Subject: A303/Stonehenge PRow - Is a Bridleway missing from the draft DCO and associated Access Plans? (Upfold: 20018352)

To the Planning Inspectorate and Highways England (A303/Stonehenge)

Drawing Title
**RIGHTS OF WAY AND ACCESS PLANS
REGULATION 5(2)(k) & 5(2)(o)
SHEET 4 OF 15**

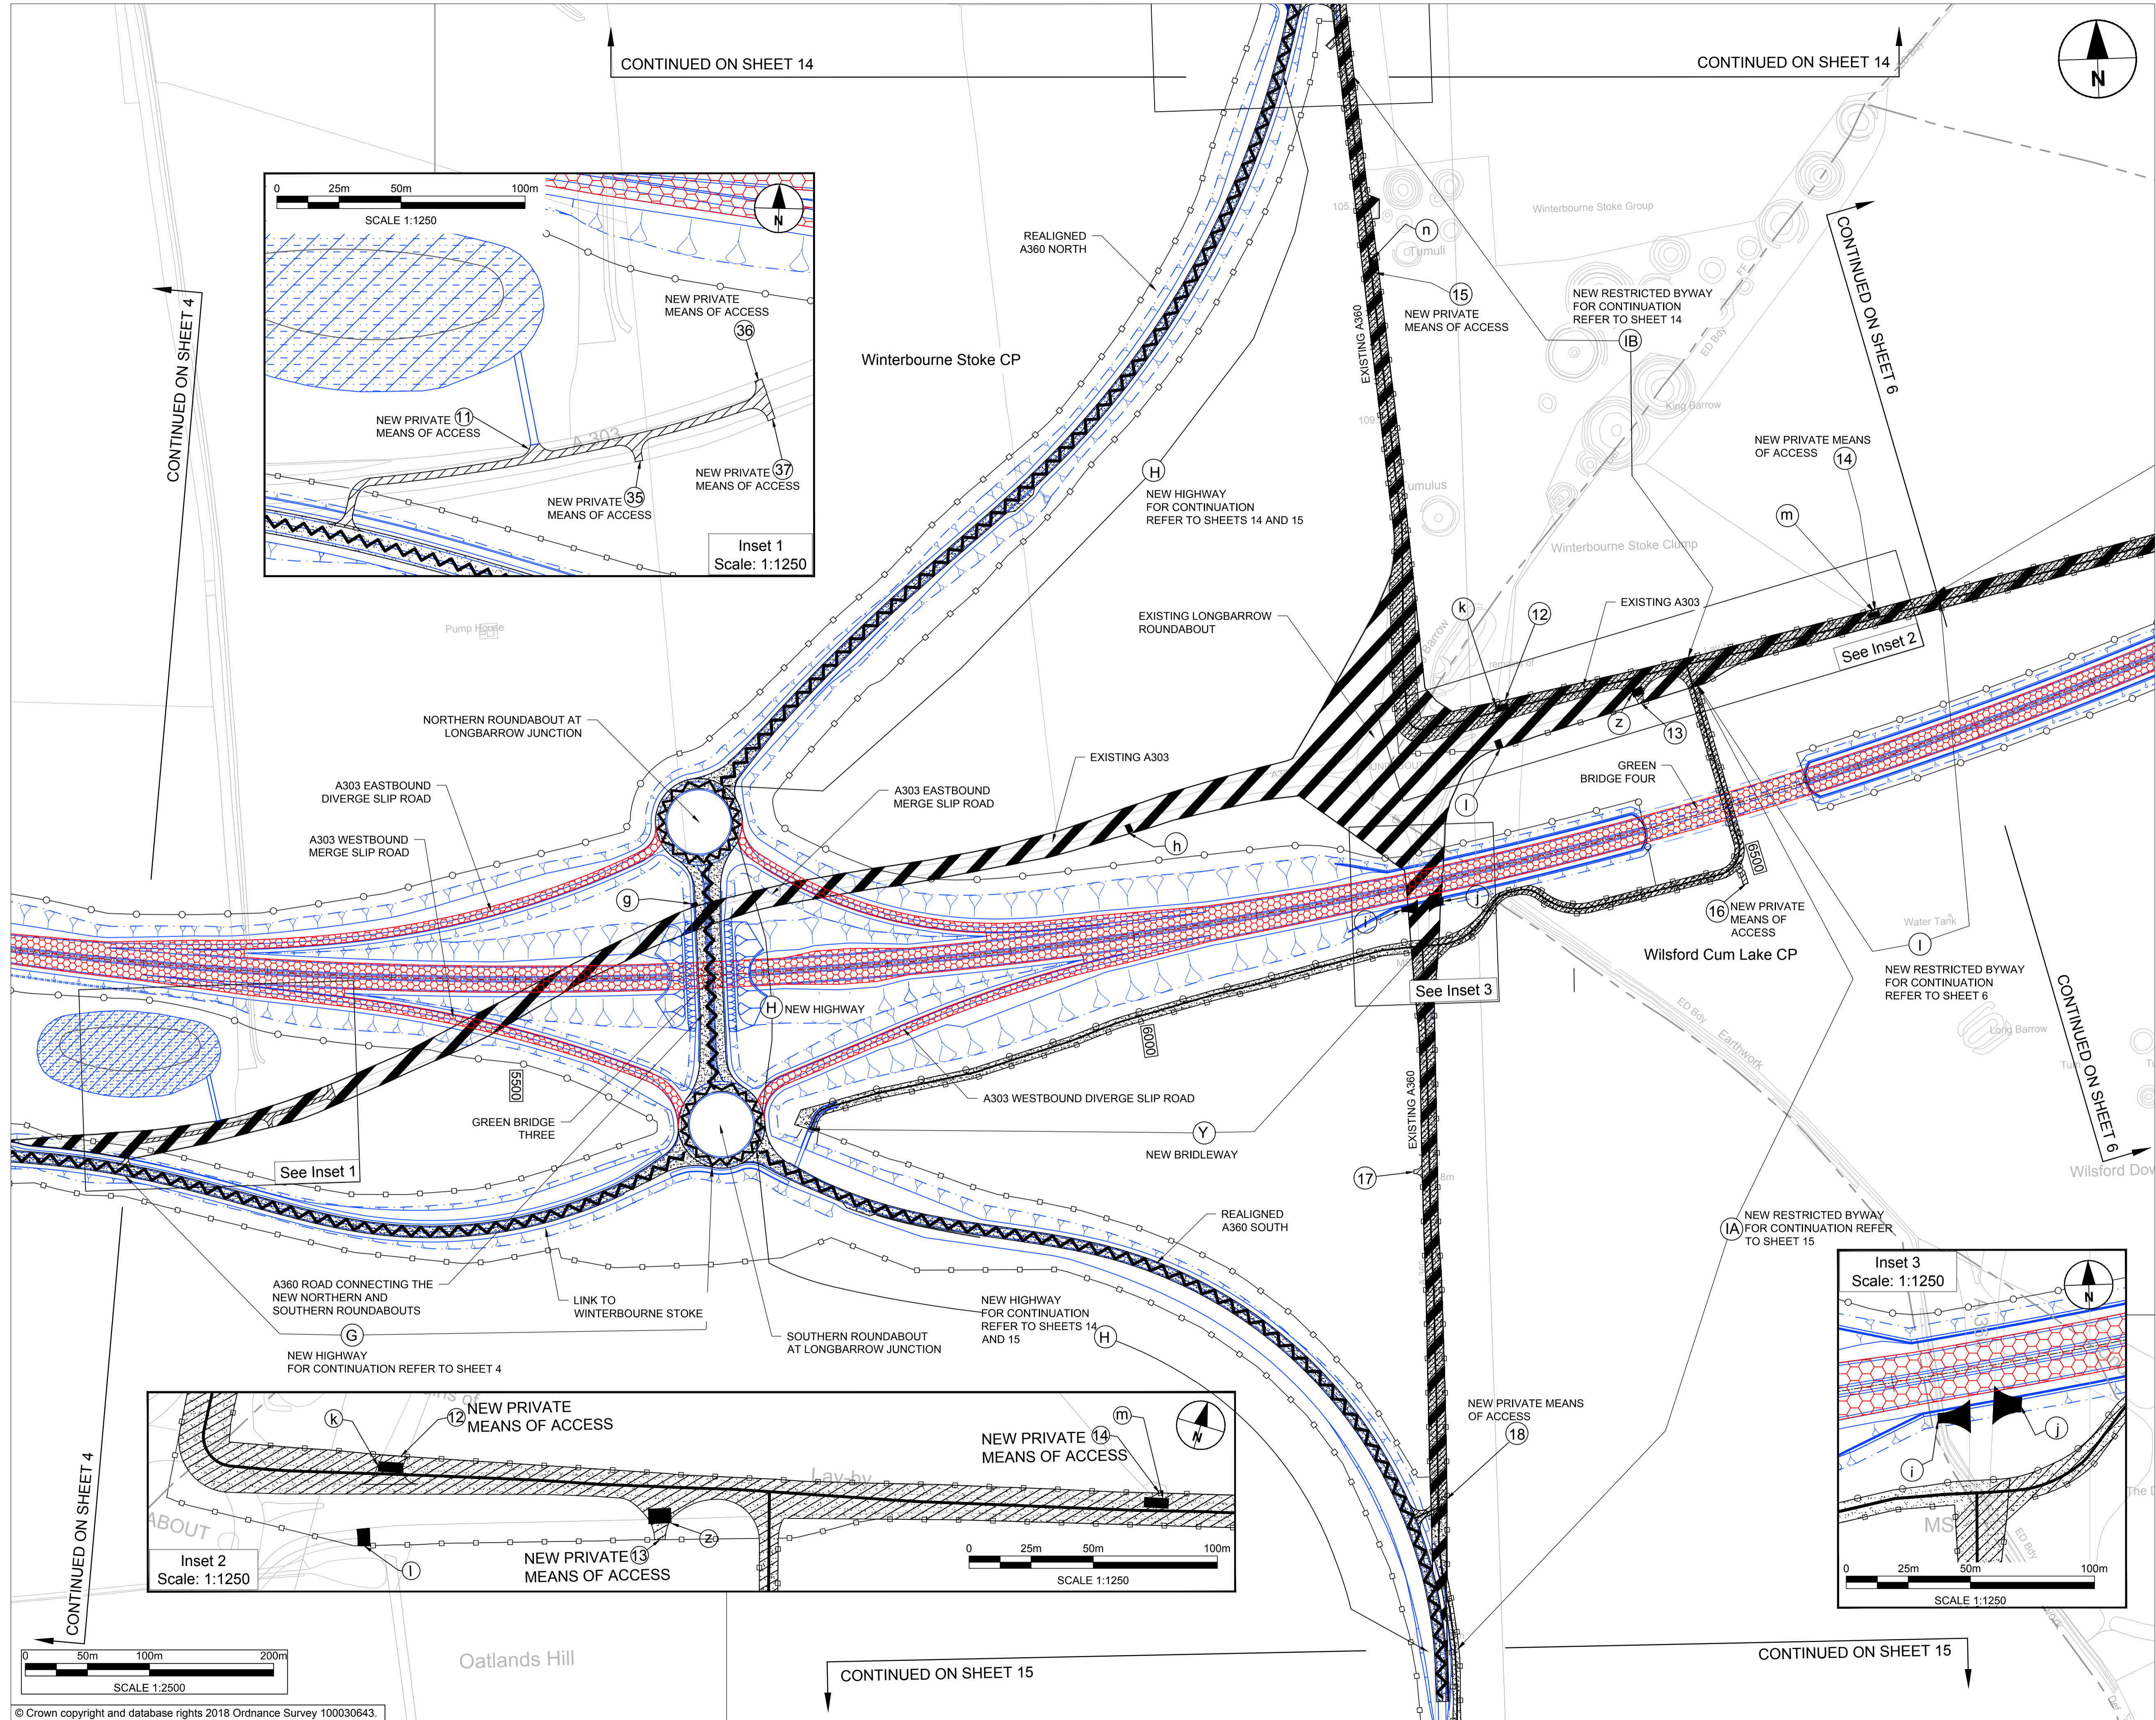
"Reference G A length of new side road between Winterbourne Stoke and the new Longbarrow Junction, from a point 650 metres south west of the existing Longbarrow roundabout (its junction with the new southern roundabout at Longbarrow Junction) in a generally westerly direction to a point 275 metres east of its junction with the byway WST06B, 1.20 kilometres to the south west of the existing Longbarrow roundabout, a distance of 615 metres (as shown on sheets 4 and 5 of the rights of way and access plans)"

Drawing Title
**RIGHTS OF WAY AND ACCESS
PLANS
REGULATION 5(2)(k) & 5(2)(o)
SHEET 5 OF 15**

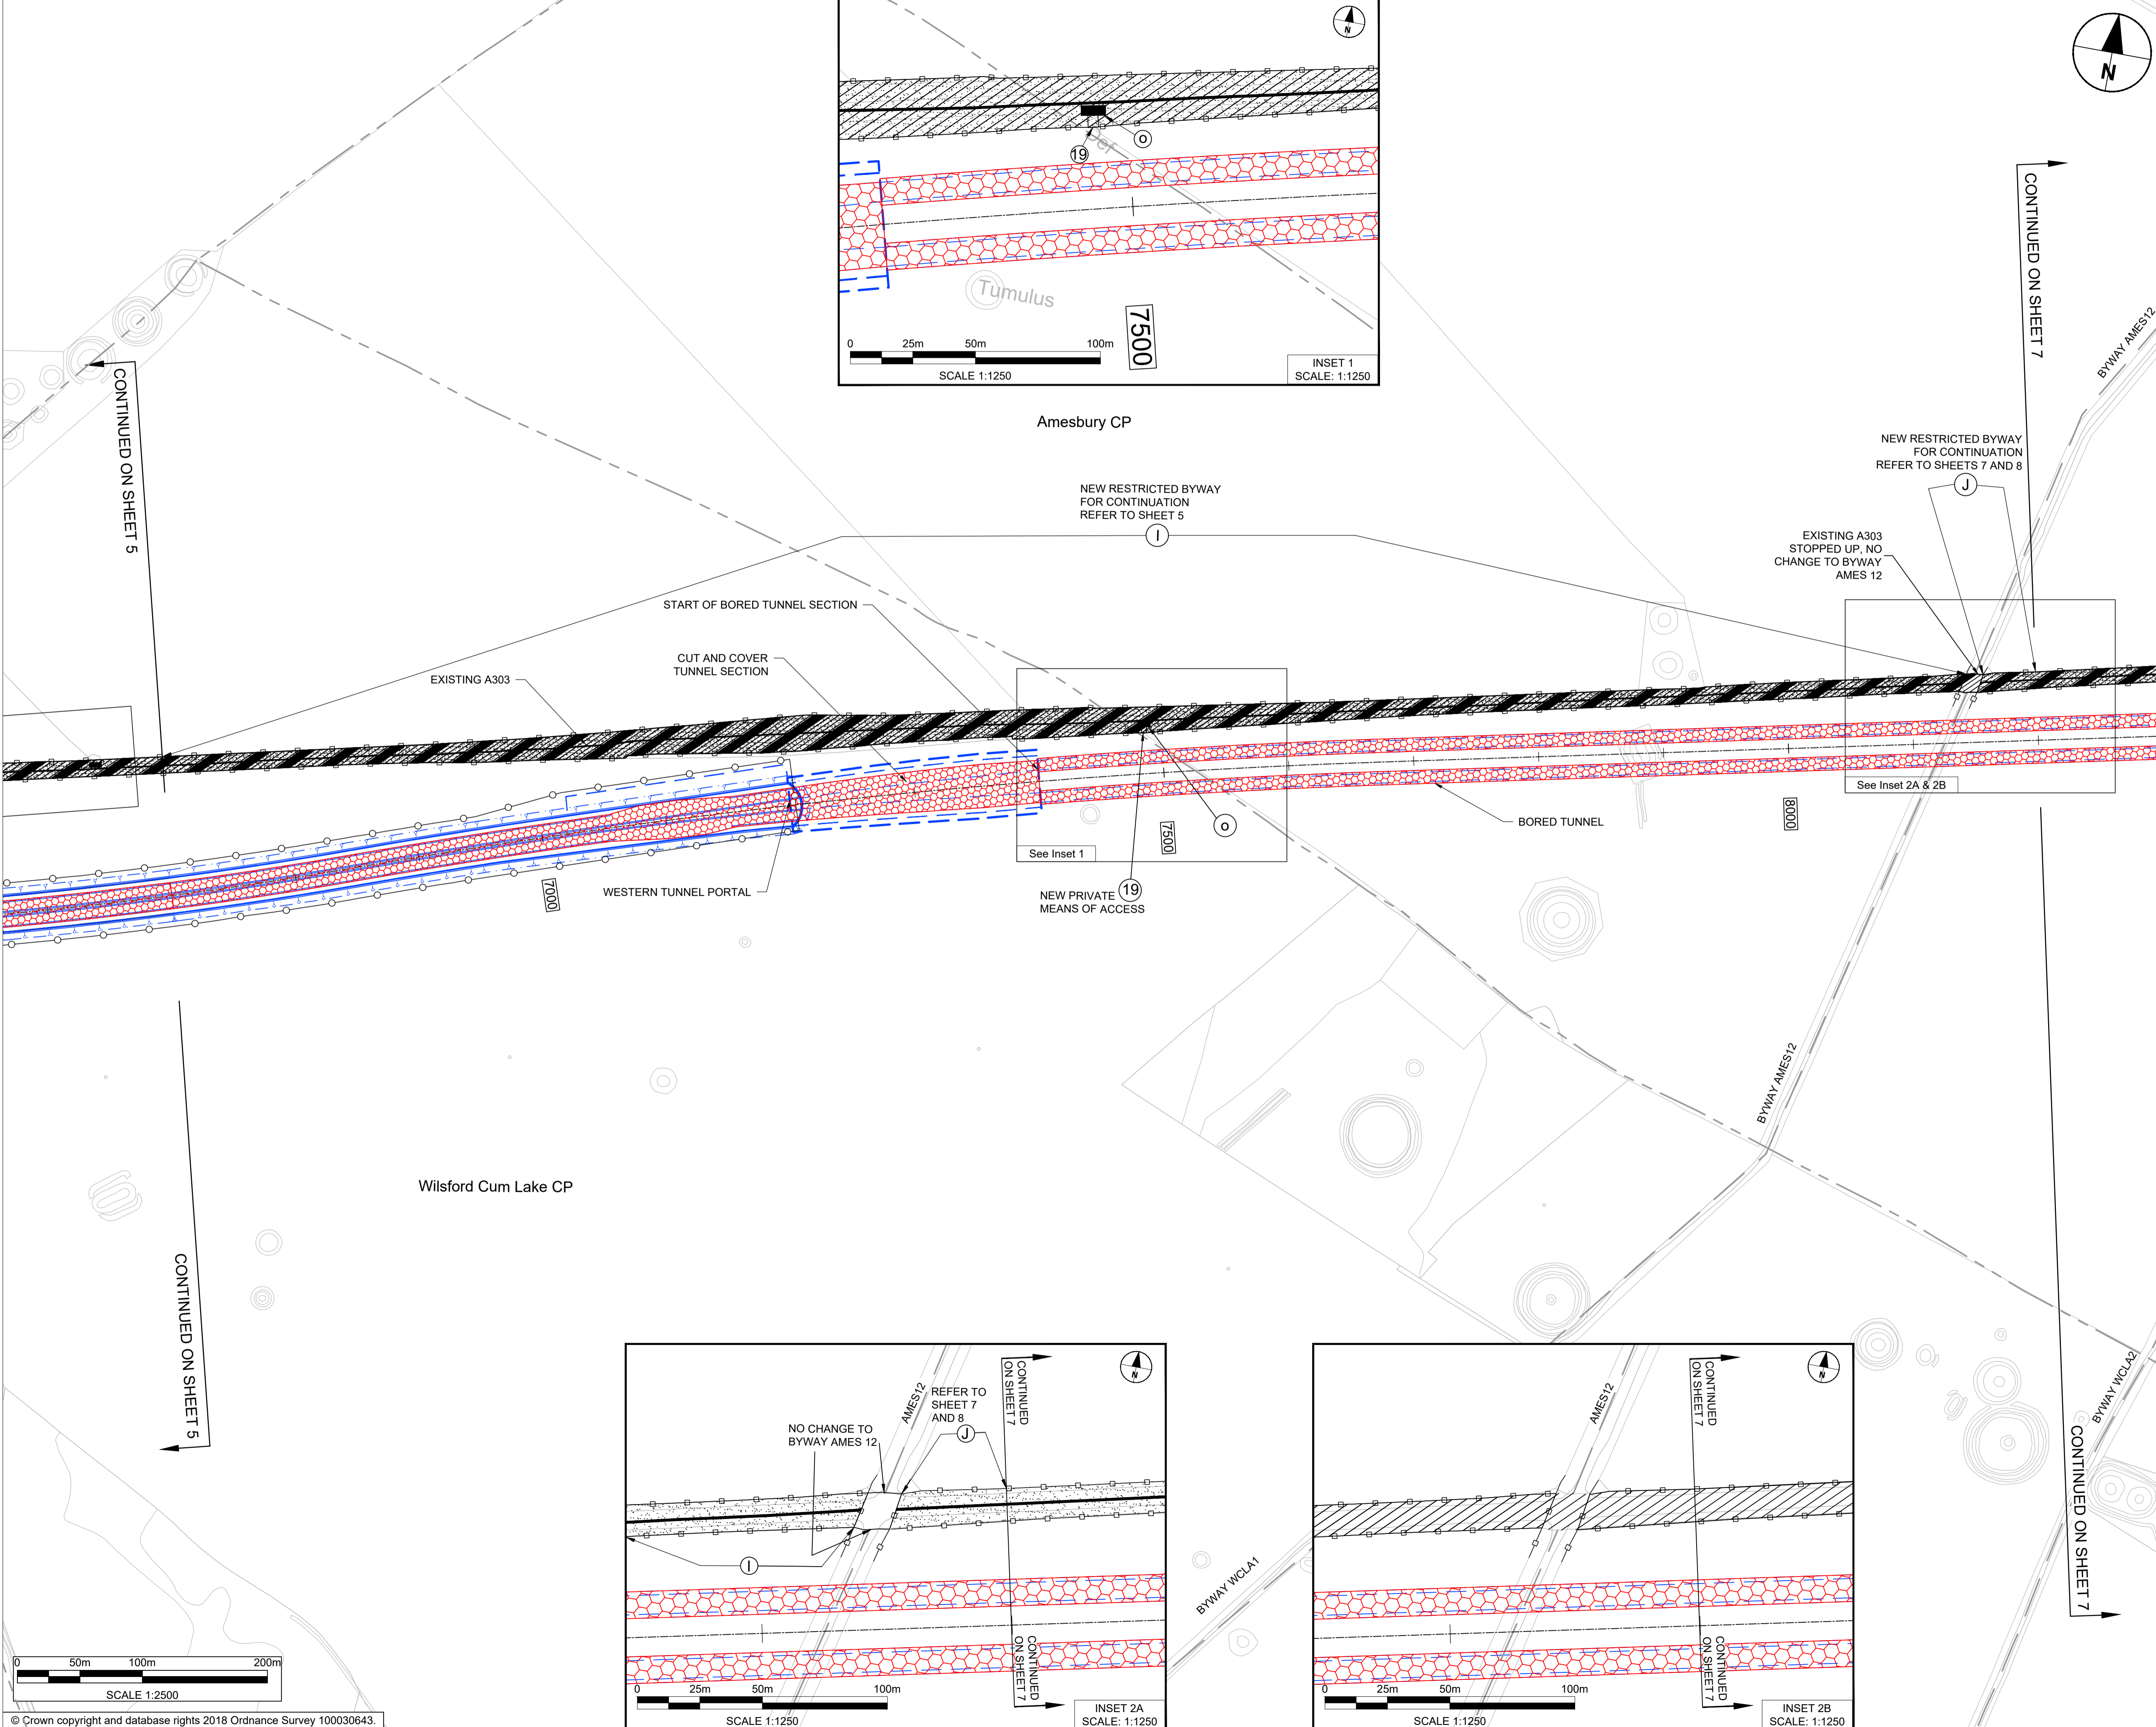
The draft DCO appears to be missing a Bridleway for the length of road labelled 'G' in the draft DCO, see page 66 of the draft DCO where it states:

which is shown on sheet 5 of document TR010025-000161-2-6-RightsOfWayAndAccessPlans.pdf,

to join up with the new Bridleway 'Y' (which then links to the east towards Amesbury along the alignment of the A303, as well as north and south alongside the A360).

- north side of the road (such that a Pegasus/Cycle crossing would be needed for the westbound on-slip onto the newly dualled A303), or to the
- south of the new road 'G' to link with new Bridleway 'Y' via a Pegasus/Cycle Crossing.

All NUM consultees would appreciate urgent confirmation of the situation with respect to this important new east-west PRoW link between Winterbourne Stoke and the Amesbury/A360 (N/S) routes. Therefore I request that this issue is considered at the planned forthcoming ISH on the draft DCO on Friday 30th August 2019.
